RESPONSE TO COMMENTS

ROLLIN RIDGE ESTATES PRELIMINARY PLAN (SP-18-001)

PCD PROJECT MANAGER - REDLINES

**PRELIMINARY PLAN**  
**ROLLIN RIDGE ESTATES**  
EL PASO COUNTY, COLORADO  
**TC & C, LLC**  
17572 COLONIAL PARK DRIVE MONUMENT, CO 80132-2209

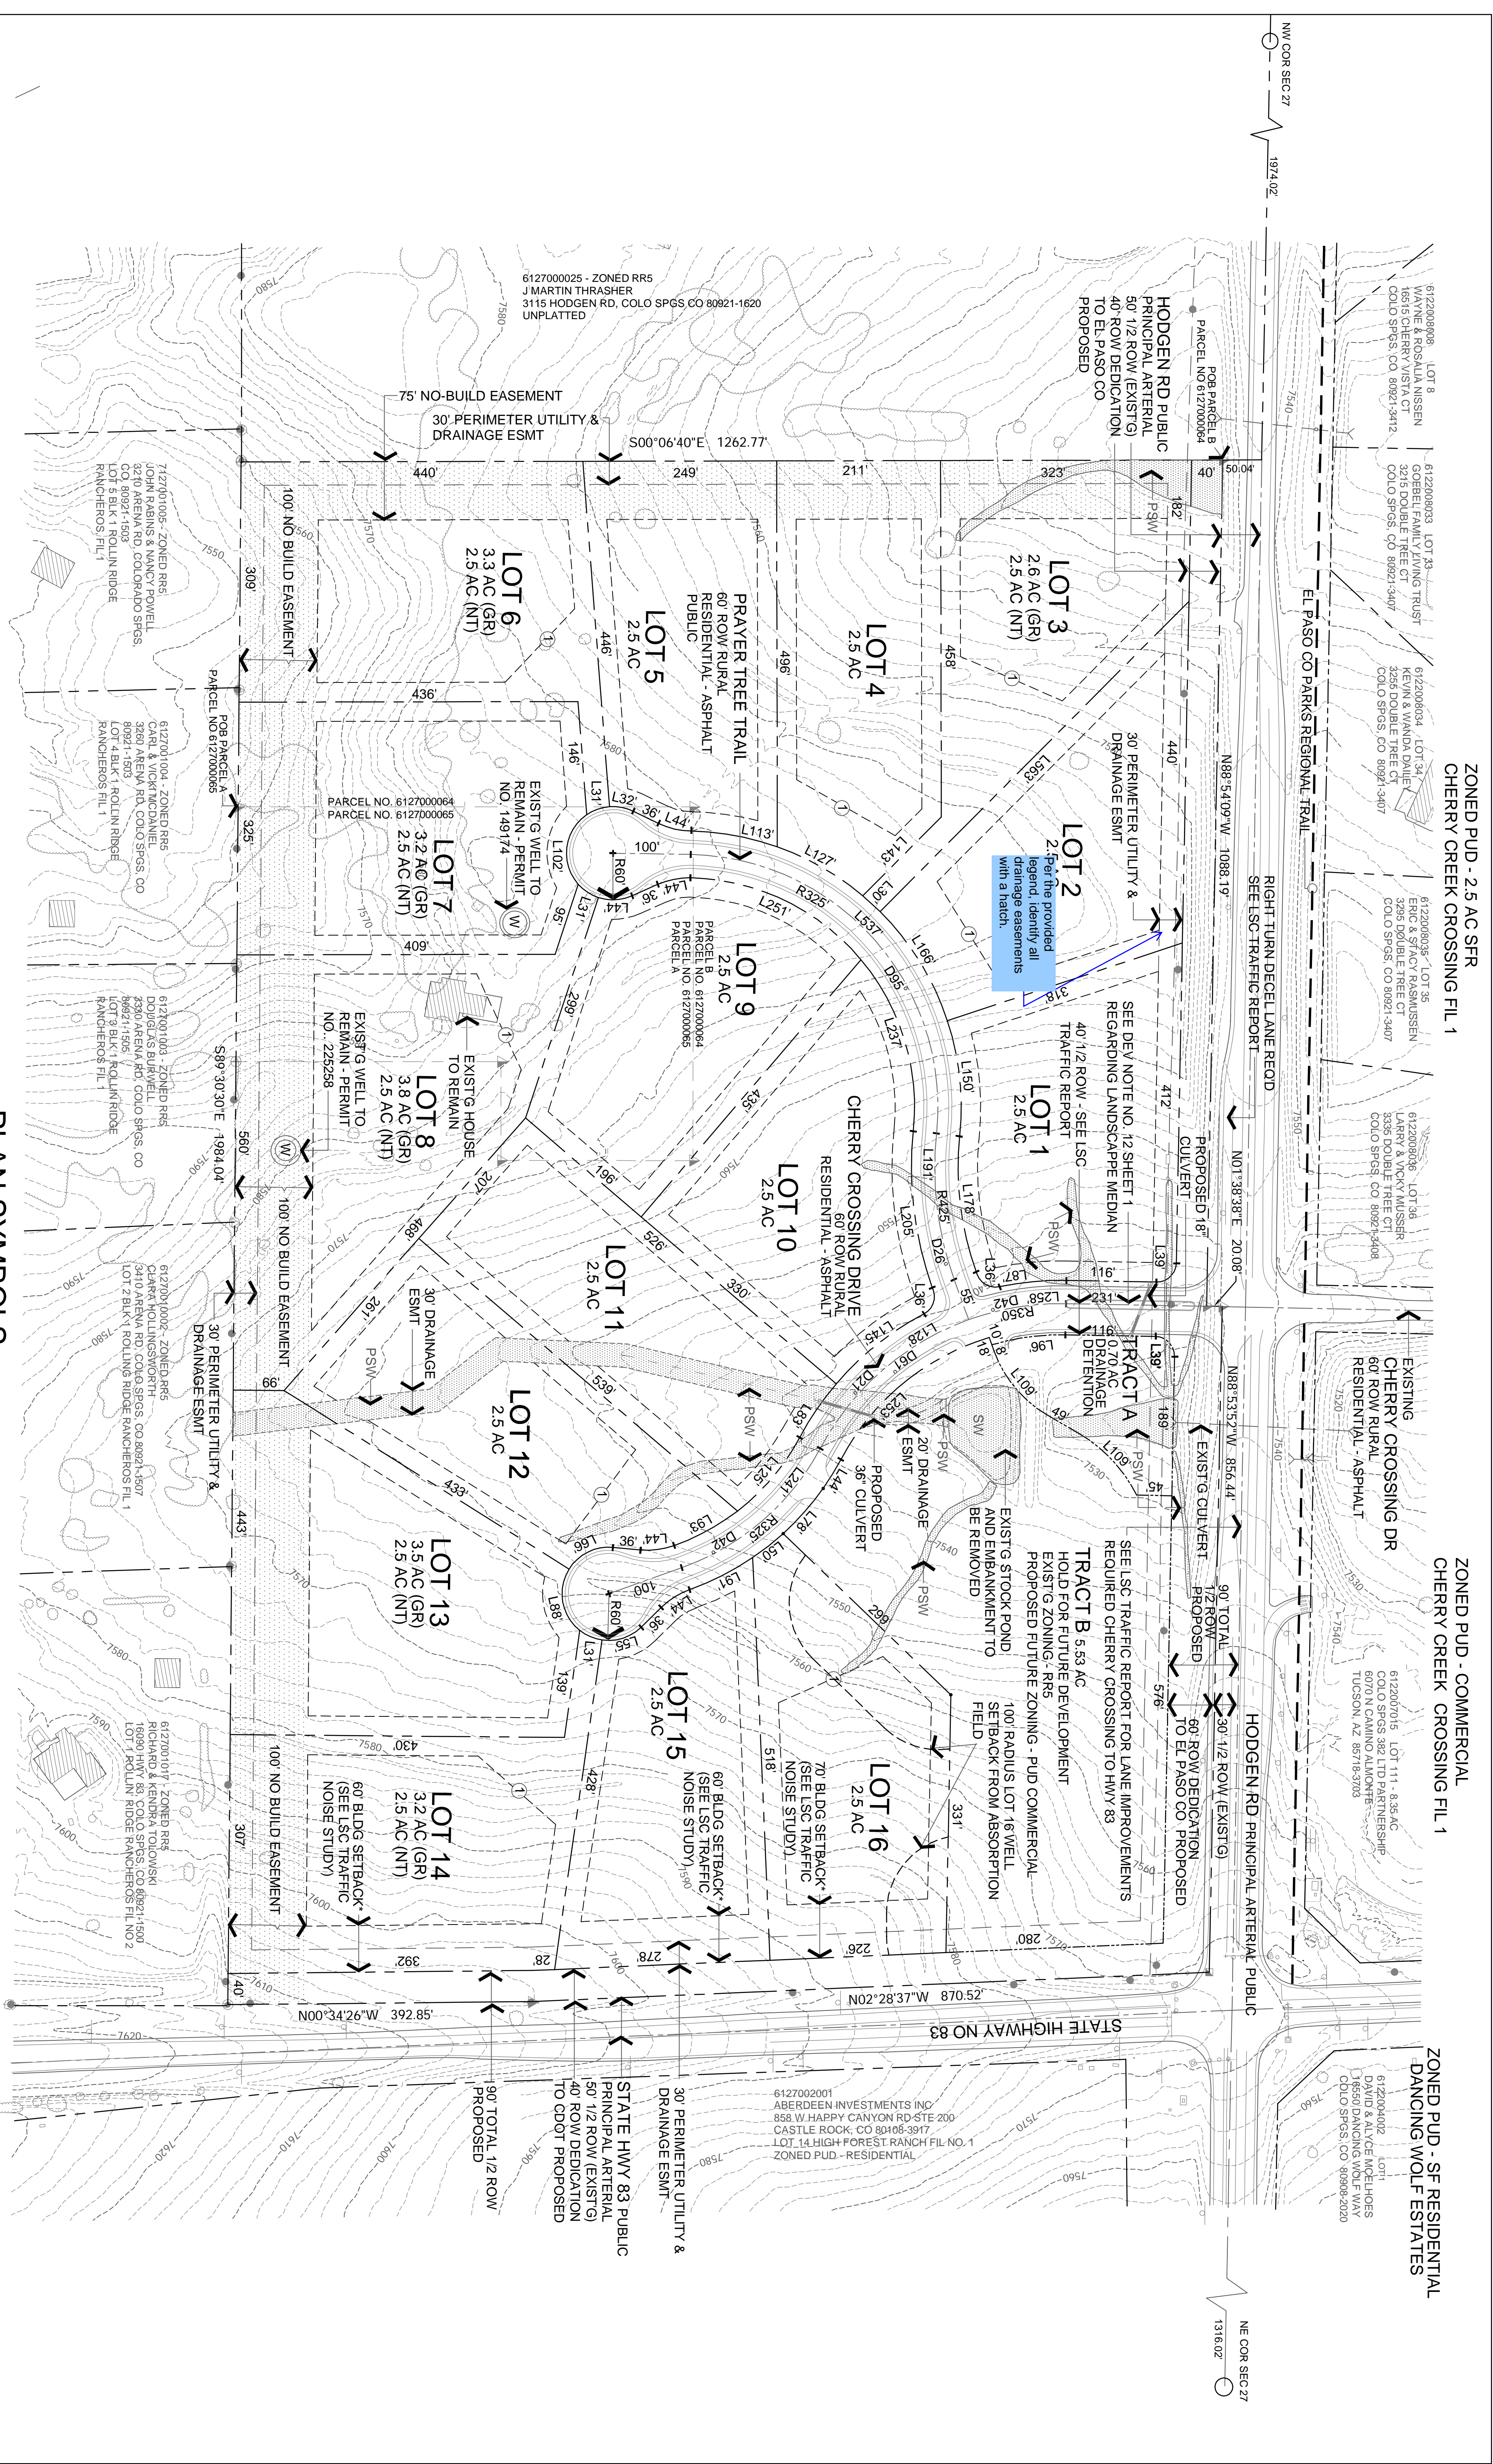
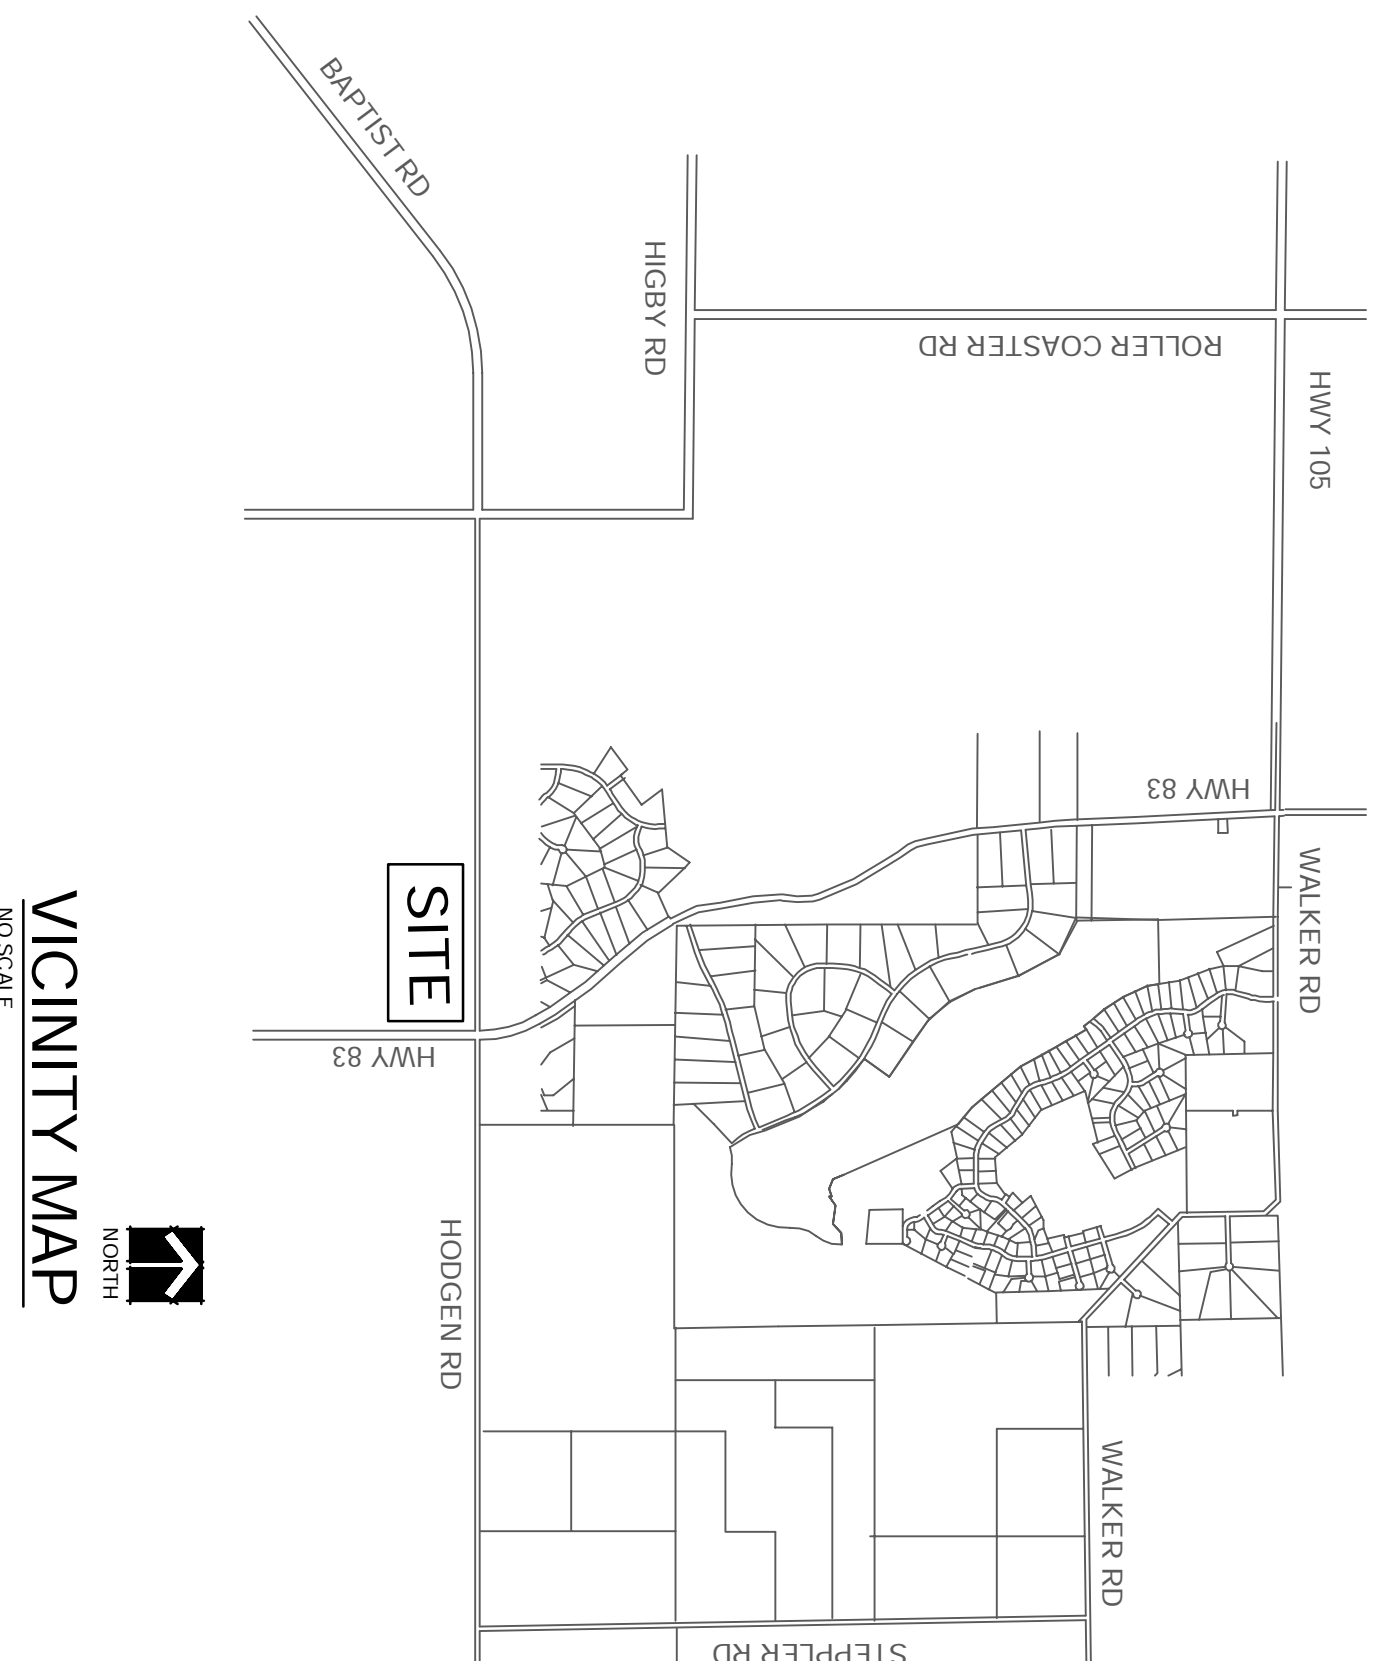
- Prel Plan Sheet 1 – *Development Notes 4 and 8 are duplications* – Development Note No. 8 has been removed.
- Prel Plan Sheet 1 – *Legal descriptions on the plan do not match the title commitment* – As shown on Sheet 2 of the Preliminary Plan, the Rollin Ridge Estate subdivision contains two assessor parcel numbers called out as Parcel A (6127000065) and Parcel B (6127000064). The submitted title commitment contains legal descriptions for three parcels: Parcel 1's legal description (6127000065) includes the ranch house and out buildings. Parcel 3's legal description (6127000064) includes the remaining unimproved portion of the ranch. Parcel 2 of the title commitment's legal descriptions defines a 20' wide vehicular access easement providing driveway access to Parcel 1 over Parcel 2's real property. As Parcel 2 of the title commitment does not describe real property, it was not included within the Preliminary Plan's legal description. Otherwise, Parcel A's Preliminary Plan legal description matches Parcel 1 title commitment legal description and Parcel B's Preliminary Plan legal description matches Parcel 3's title commitment legal description. I have added a note to the Preliminary Plan's legal descriptions identify which Preliminary Plan legal description corresponds to which title commitment legal description.
